RE: Attached letter from Kirklees Council regarding application number 2024/91008 at location adj, 115, Westfield Lane, Wyke, BD12 9LY

Bridges & Structures Manager
Structures Section

Client Yorkshire Choice Homes Limited	
Westfield Lane, Wyke GABION WALL SECTIONS	
Scales 1:1250 1:200 @ A1	Date Feb 23
Drawing Number 2023-018-101	Revision - CON
Drawn by YCHC

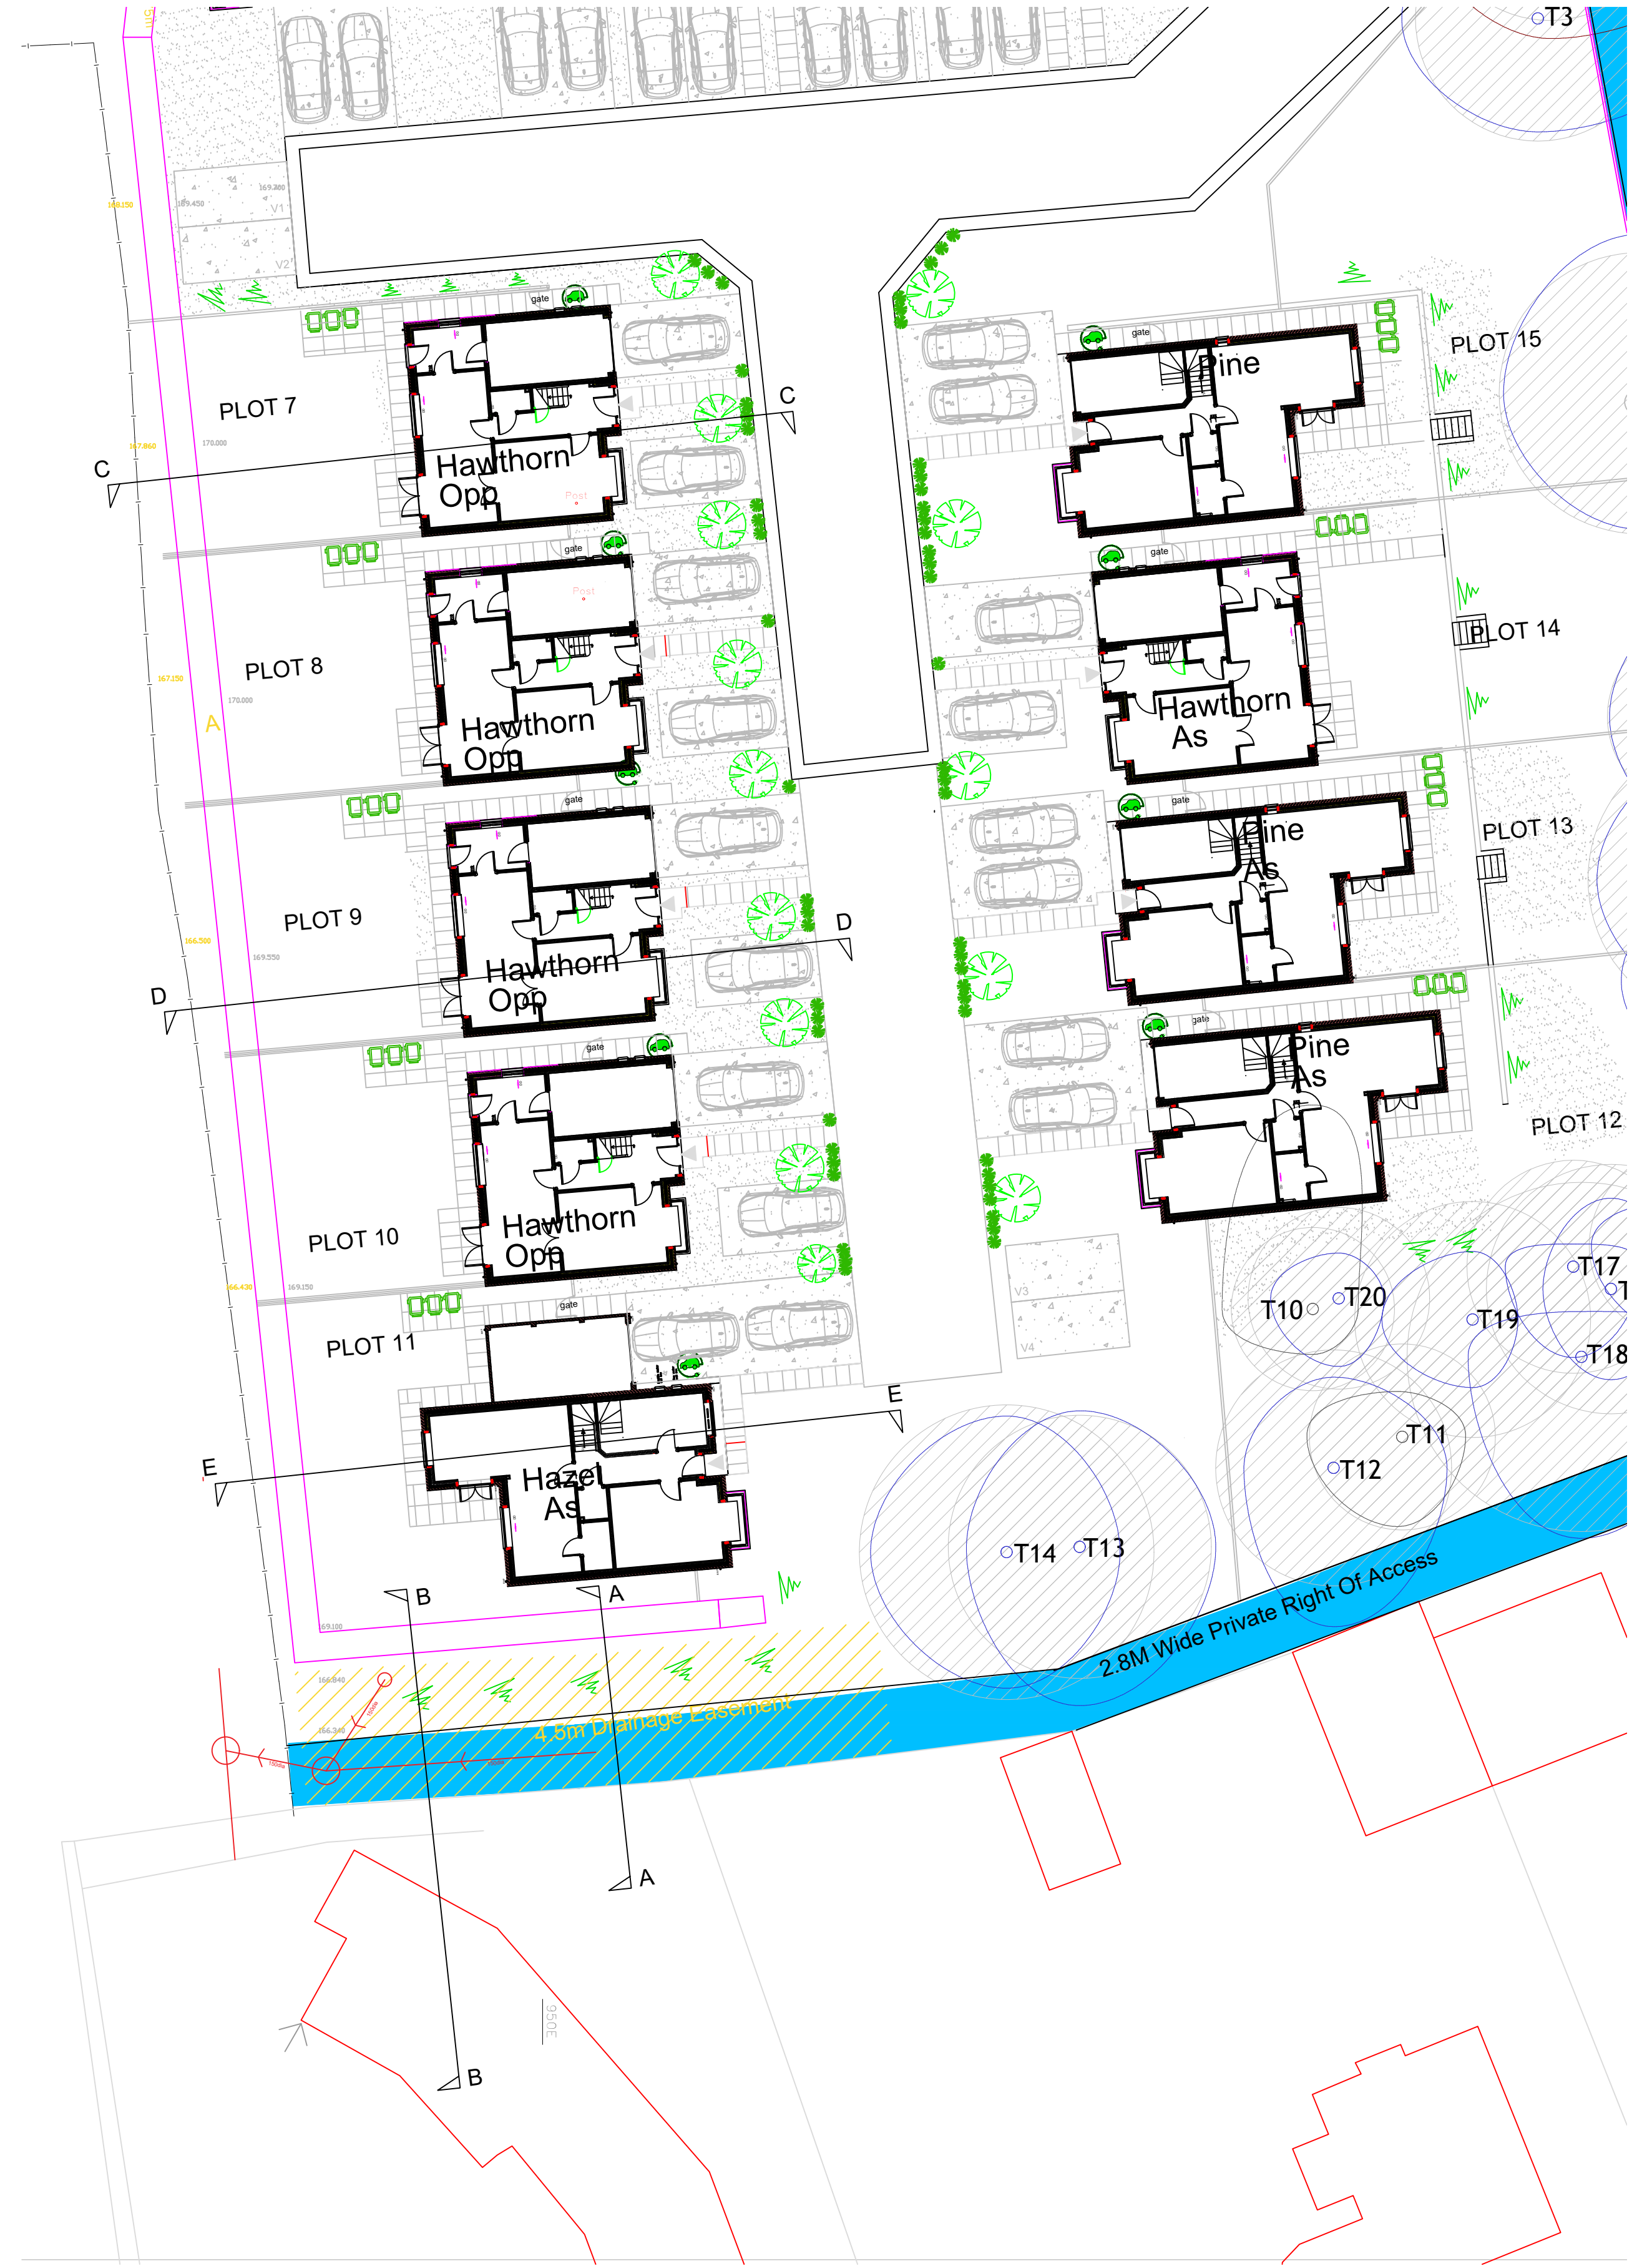
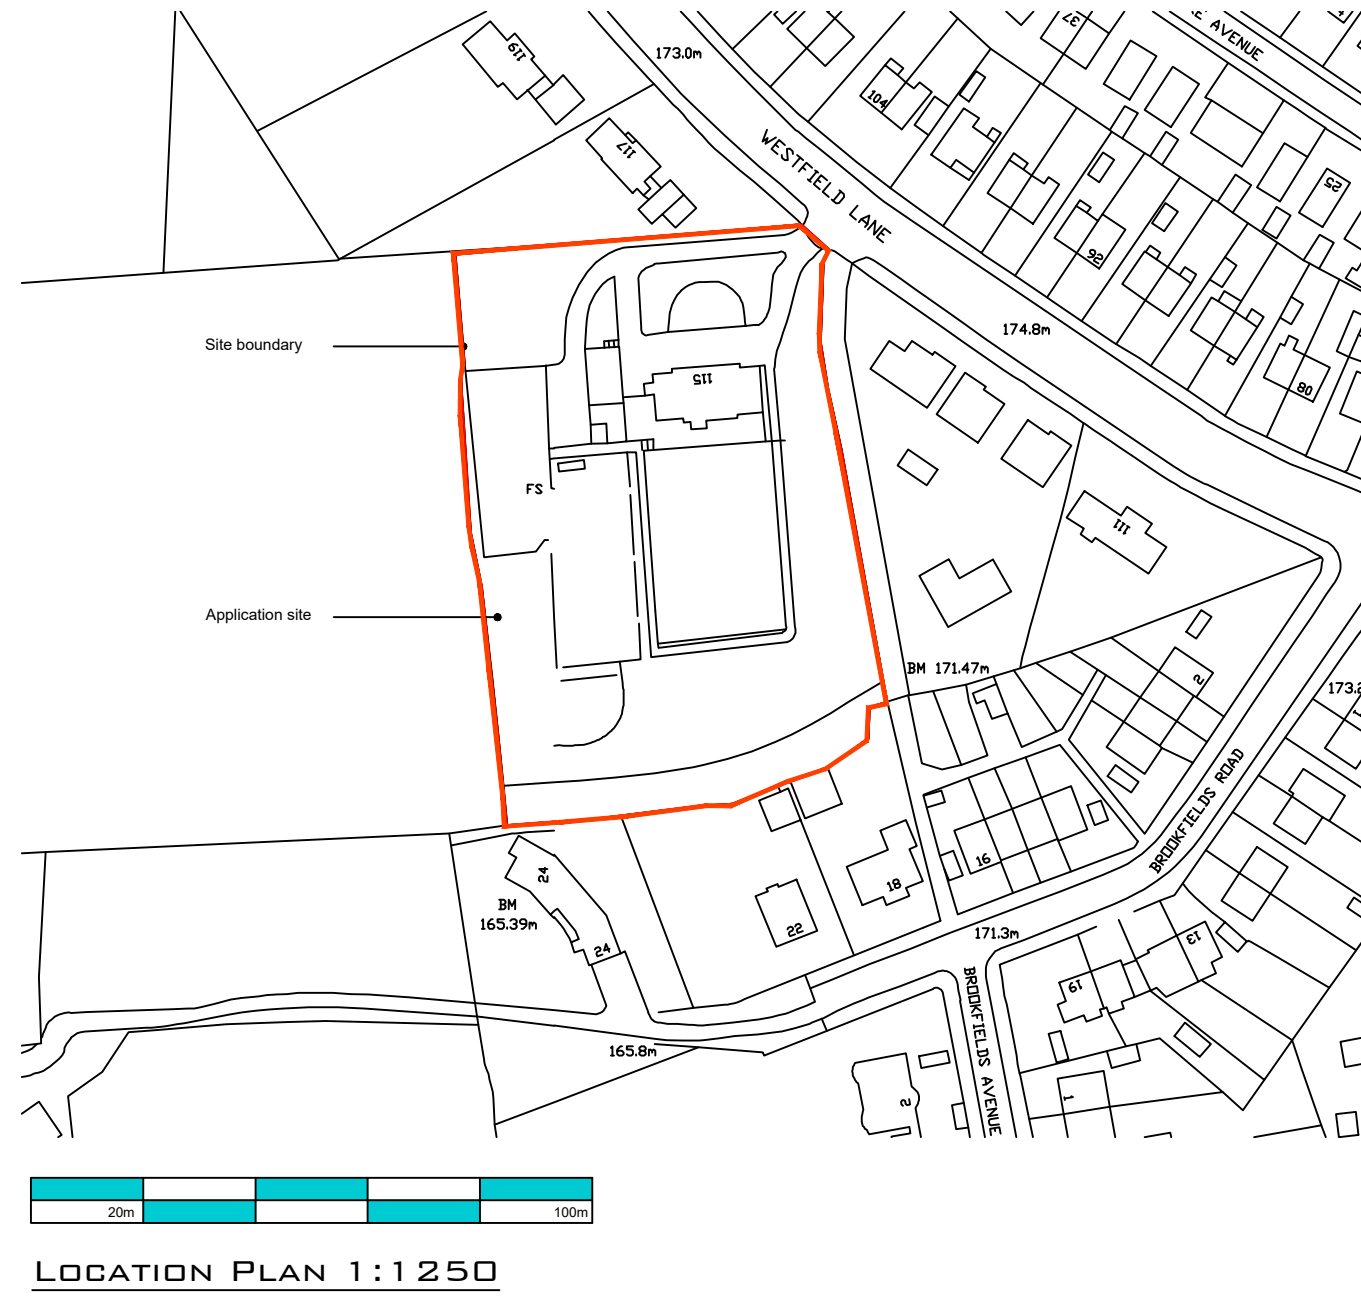
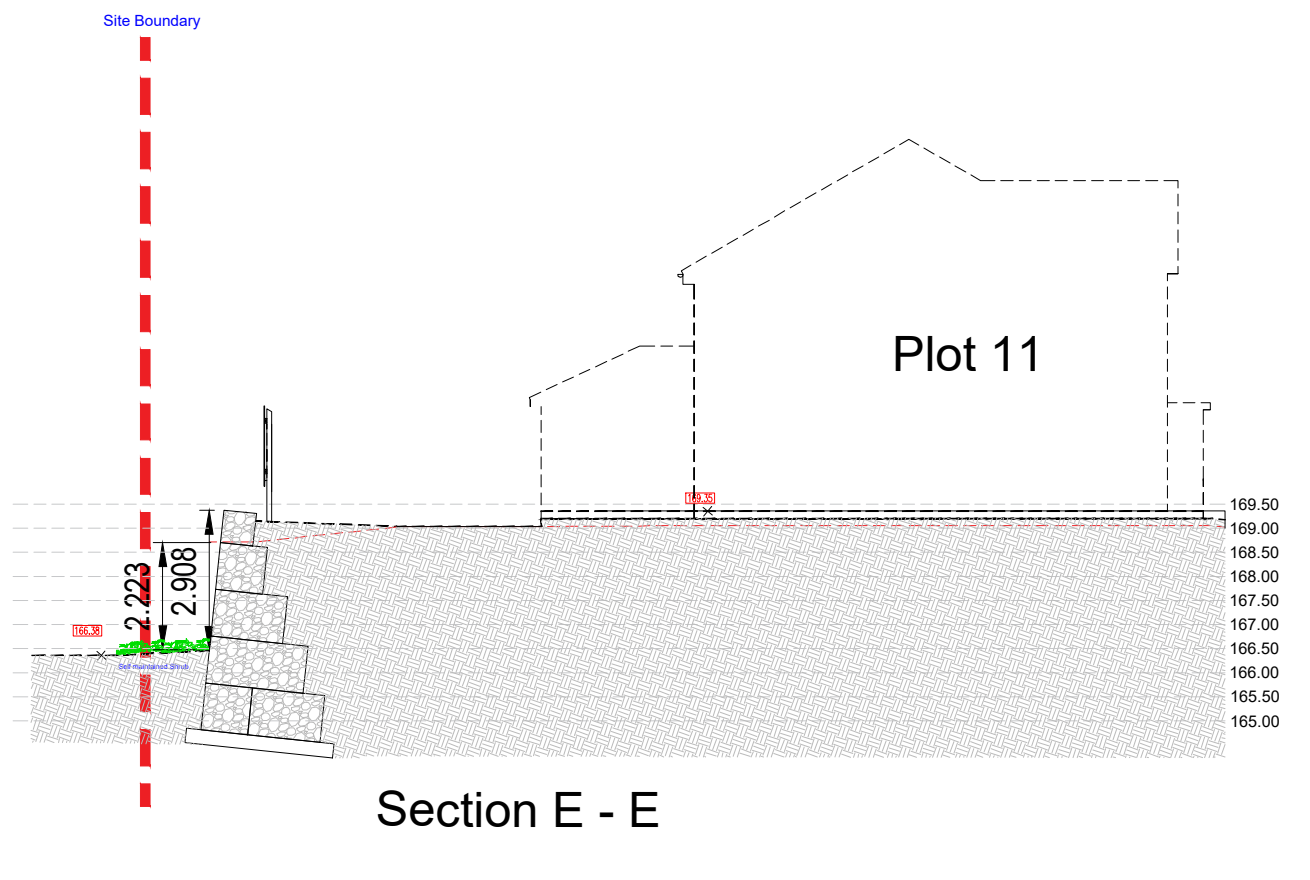
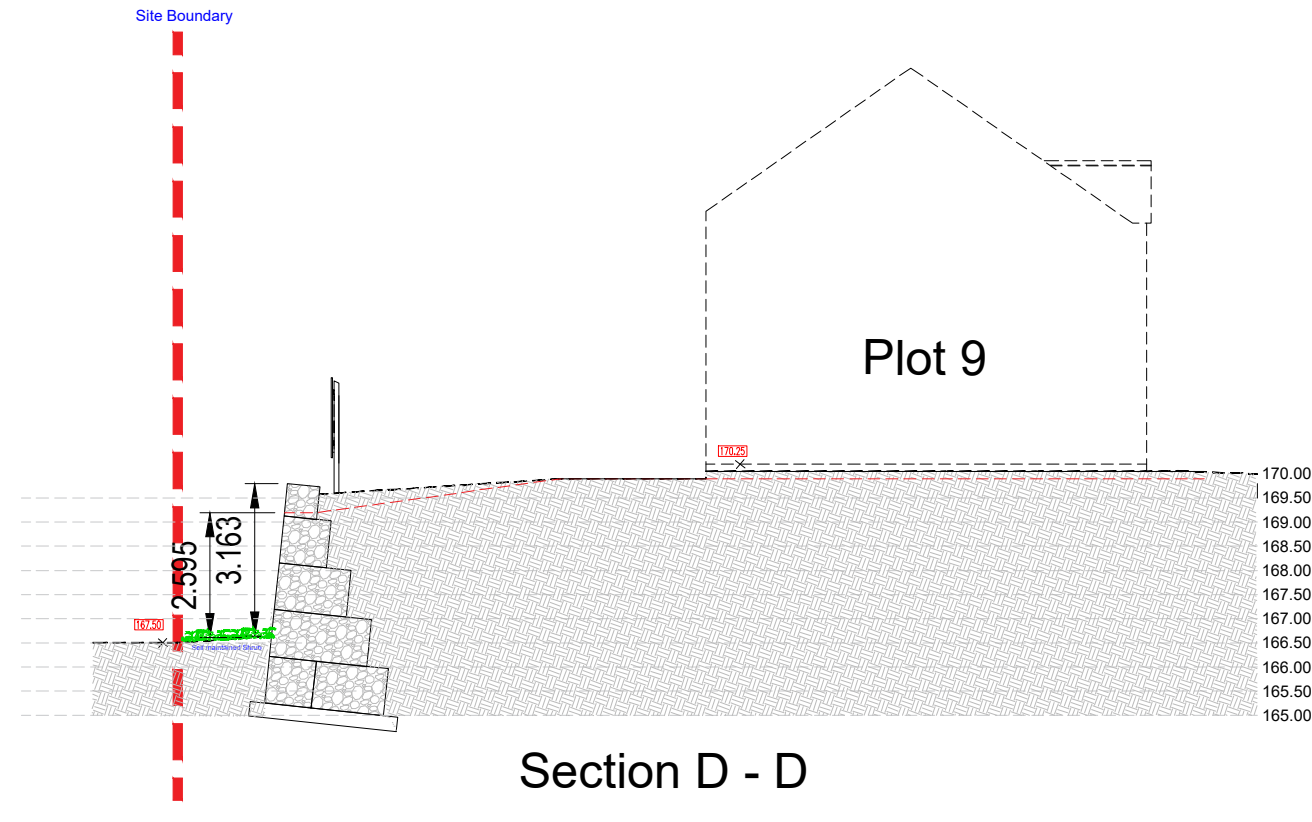
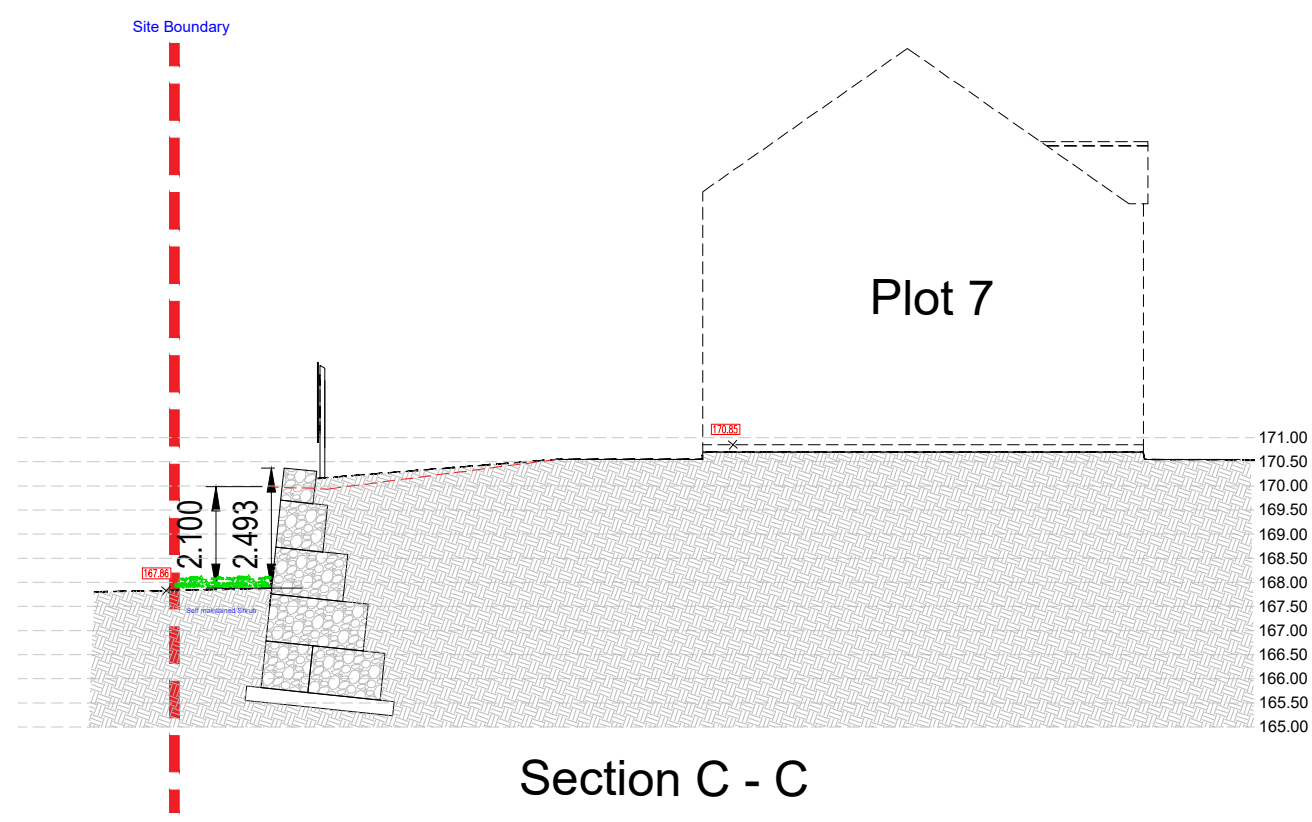
- 1) Before the development commences, the design of proposed retaining walls adjacent to the existing/ adoptable highway including footpath (Ref SPE/31/10) shall be submitted (via the submission of AIPs) and approved by the Highway Authority in writing. The approved scheme shall be implemented prior to the commencement of the proposed development and thereafter retained during the life of the development.
